Engineers Comments Regarding Surface Water Drainage

Application Reference:	M/58/26/HH	Reviewer Reference:	ADC/EXT5/AF
Planning Officer:	Rhiannon Lloyd	Date of Review:	29/09/2026
Site Name:	15 East Avenue Middleton on Sea Bognor Regis PO22 6EG		
Application Description:	Detached Garden room		
Assessment Number:	1

PROPOSED DETACHED GARDEN ROOM AT 15, EAST AVENUE, MIDDLETON-ON-SEA
FOR MRS. F. DAVIES - COSTER.

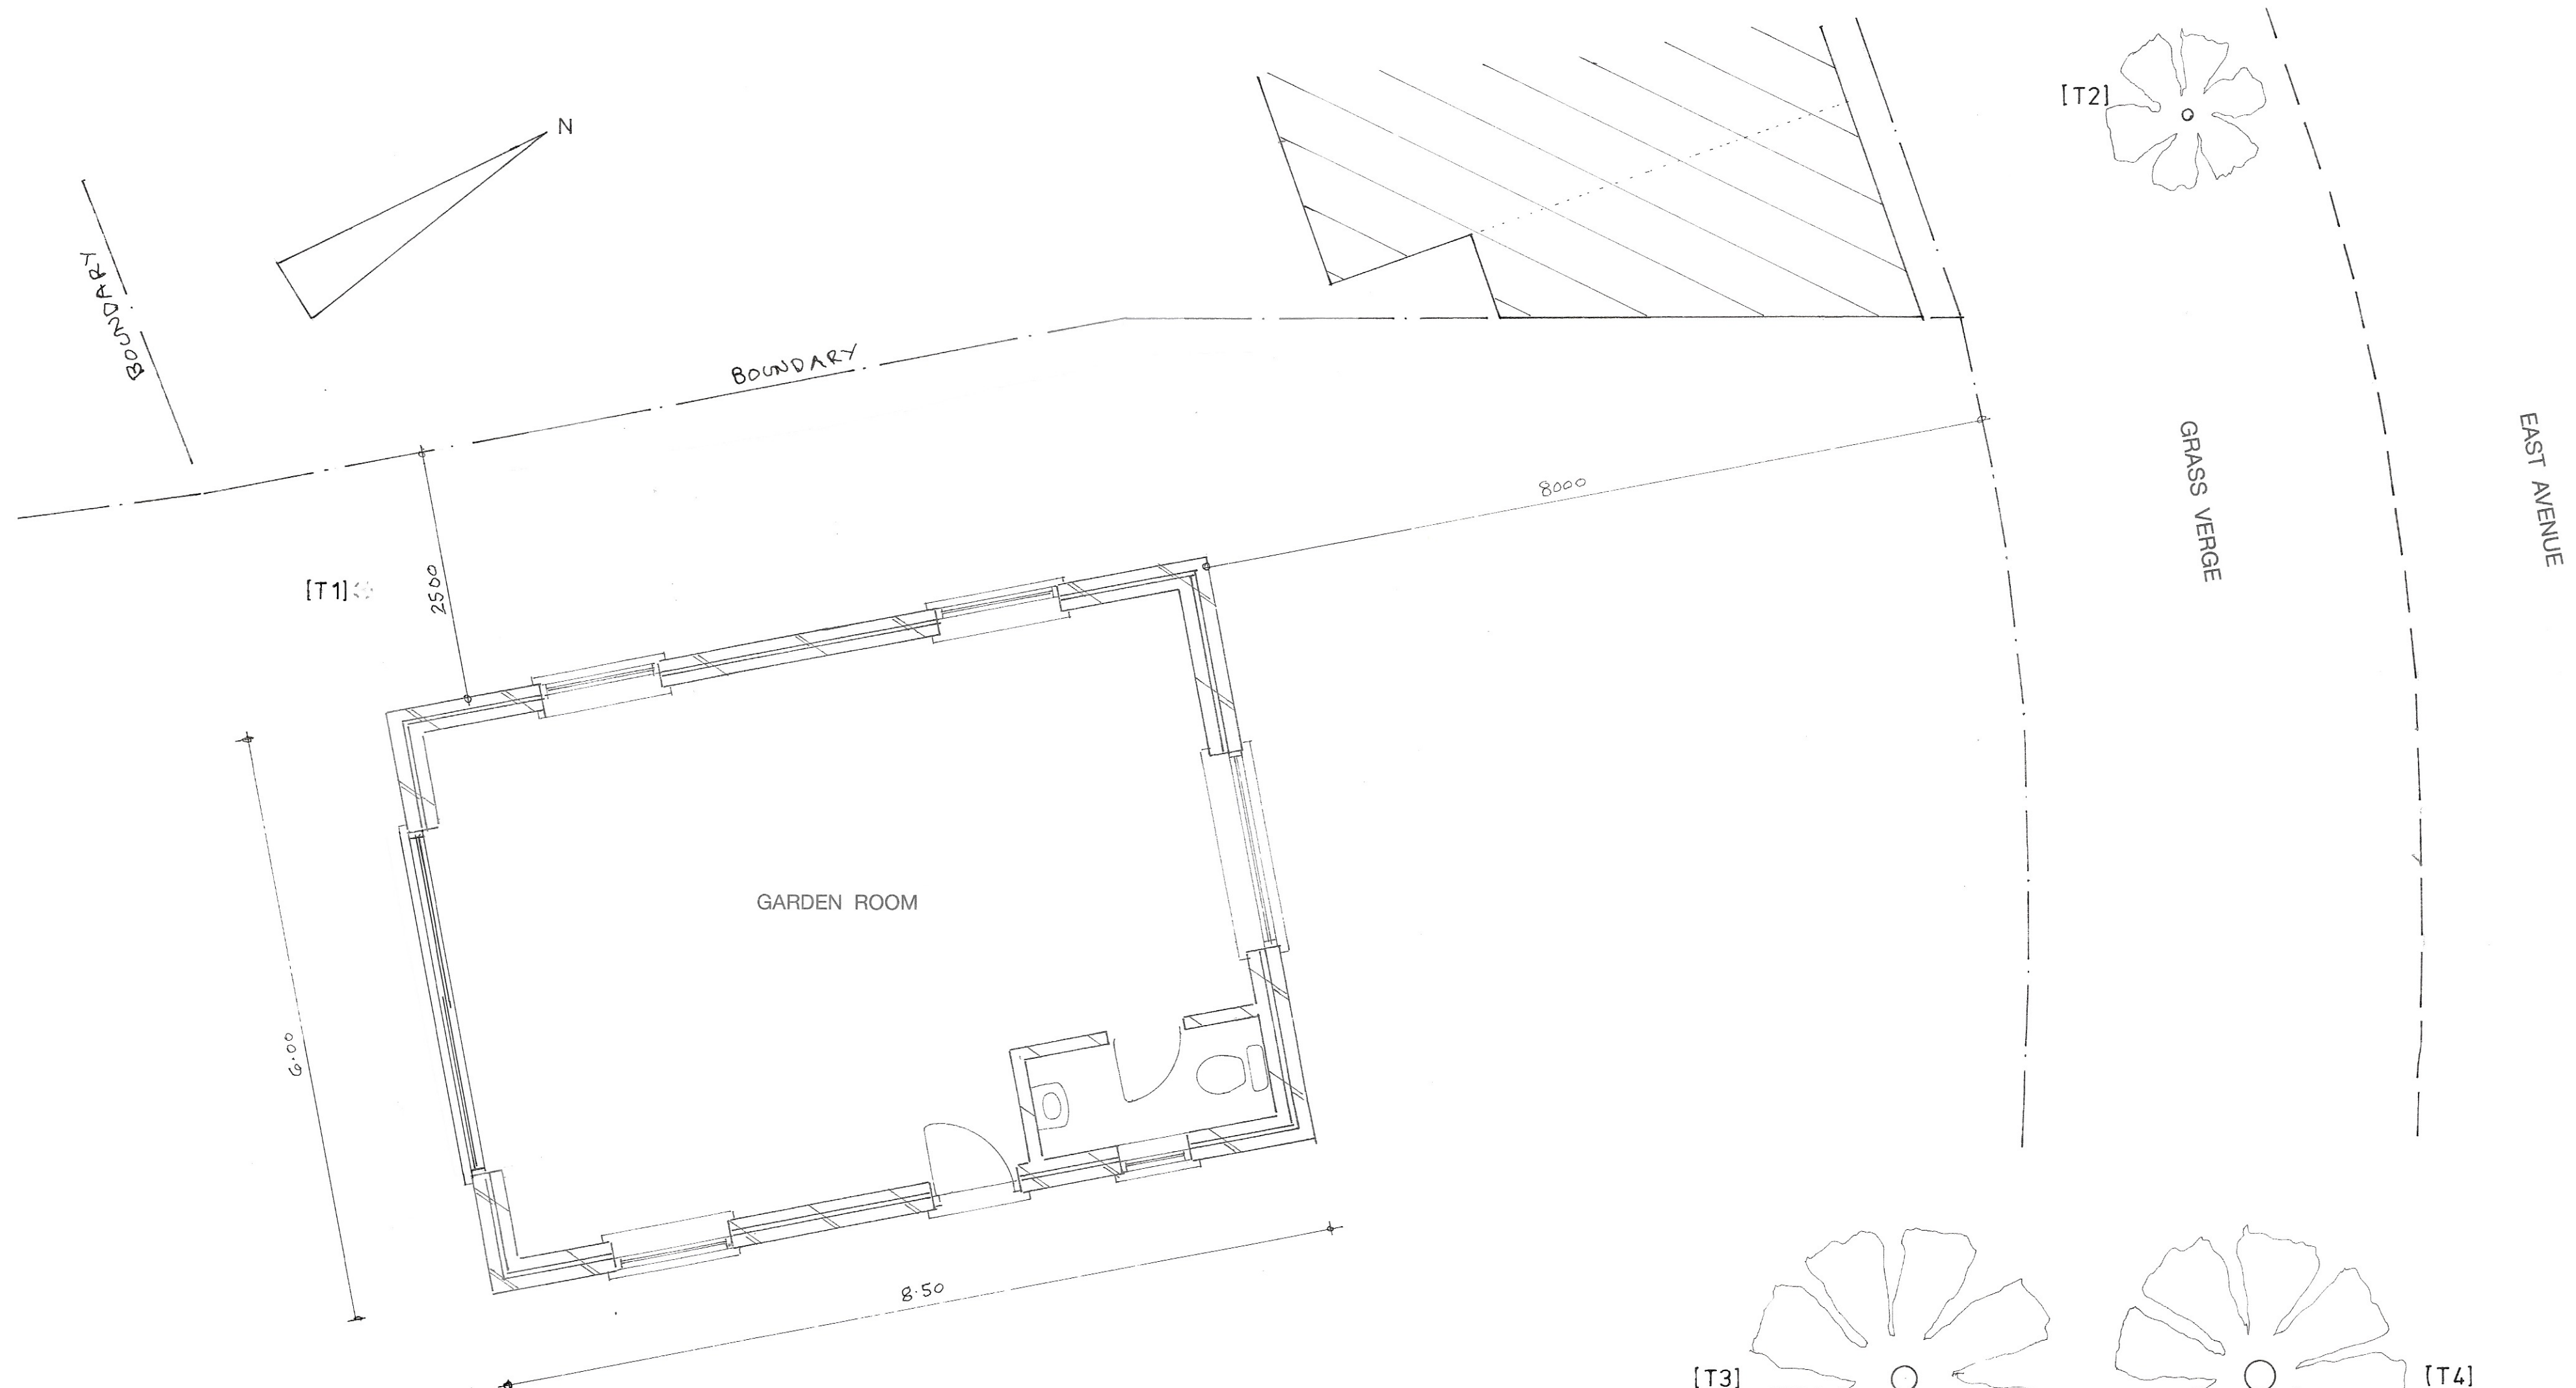
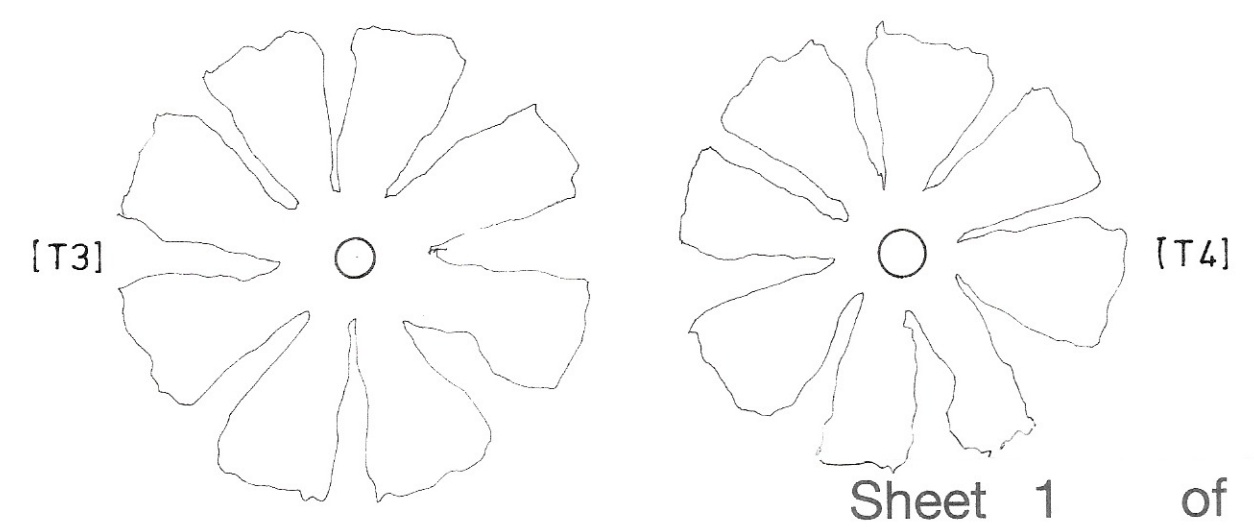
- 3.1. The outline calculations provided for the drainage system are not in accordance with sustainable drainage standards. The additional area should be attenuated, or the infiltration feature sized to accommodate large return period storms.
- 3.2. The drained area should be clarified and runoff calculated for the design storm based upon up to date rainfall data. Guidance is provided on ADC webpages - <https://www.arun.gov.uk/surfacewater>.
- 3.3. Management of extreme rainfall is not currently in accordance with the requirements of the NSfS Standard 3. Therefore, we **object** to the application.

- 4.1. No assessment for water quality is provided with the application and water quality mitigation is not currently incorporated into the design.
- 4.2. However, there is no new trafficked areas shown on the layout and measures to mitigate runoff from roof areas and paths are likely to be able to be integrated at technical design stage.
